Installation of two outfalls at the Saltbox Development, Shripney Road

EPR-JB3756SF

Permit reference: EPR-JB3756SF- Installation of two outfalls at the Saltbox Development, Shripney Road

From: PSO West Sussex <PSO [REDACTED]>
Sent: 02 December 2020 10:43
To: Mike Griffin_archive
Cc: David Gallimore; Brian McAllan; Kendall, Annabelle
Subject: RE: [Hydrock: 13319_1-SBNO] RE: EPR/JB3756SF - Installation of 2nr outfalls at Shripney Road, Saltbox - Shripney Manor Ditch___further information and fees required

ARUN DISTRICT COUNCIL INFORMATION

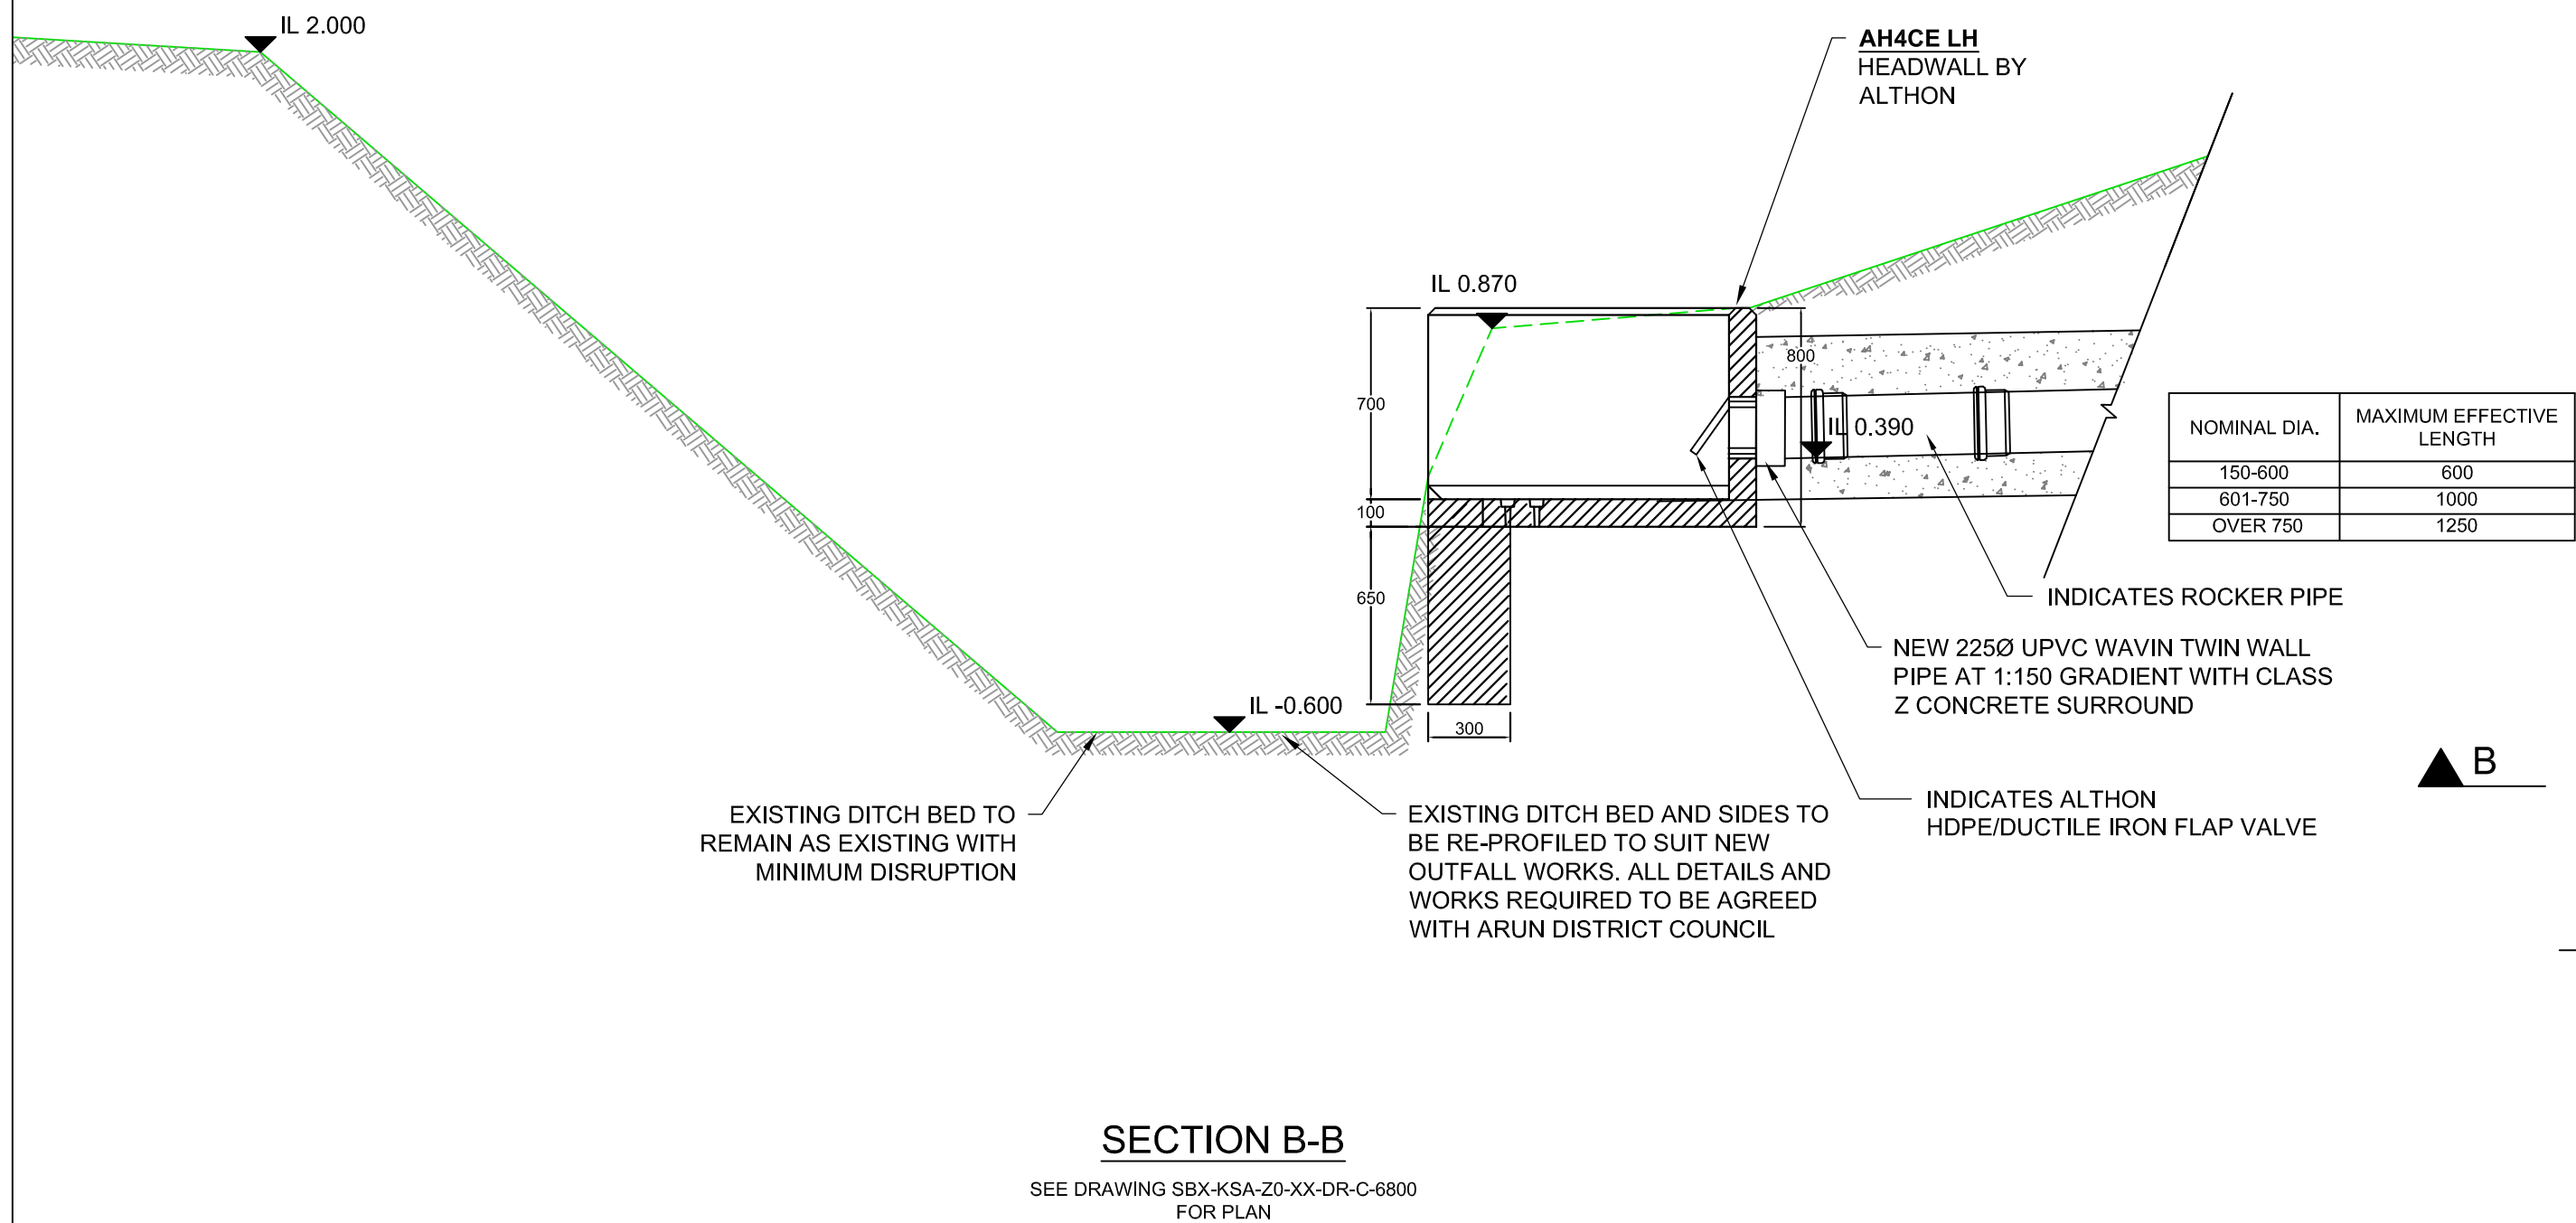
- An updated Form A which clearly defines the operator and agent for the permit;
- Further details regarding the angle of the proposed outfalls and mitigation measures in the form of bank protection;
- A revised method statement which provides greater detail as to the mitigation of ecological and environmental aspects of the site location

I did note some inconsistencies in the method statement which still shows the angle of the proposed headwalls at a 90 degree angle, but I have noted the changes on the main site drainage strategy and cross sections plans.

Regarding the bank protection mitigation measures, our Fishers, Geomorphology and Biodiversity team have confirmed that if flows are restricted by hydrobreaks to the levels specified, and initial discharge is onto concrete chamber then we would have no need for lining the bank with mattress protection.

We are reviewing the angle of headwall with the contractor and will update / re-issue the details accordingly.

With the adjustment in the headwall angle and the relatively low discharge rates it is considered to lessen the impact of the outflow on the adjacent bank. We are therefore proposing to remove the erosion blanket from the proposals (from what is currently shown on the attached). This will also reduce the ecological impact of the works during construction. We trust that this will be acceptable.
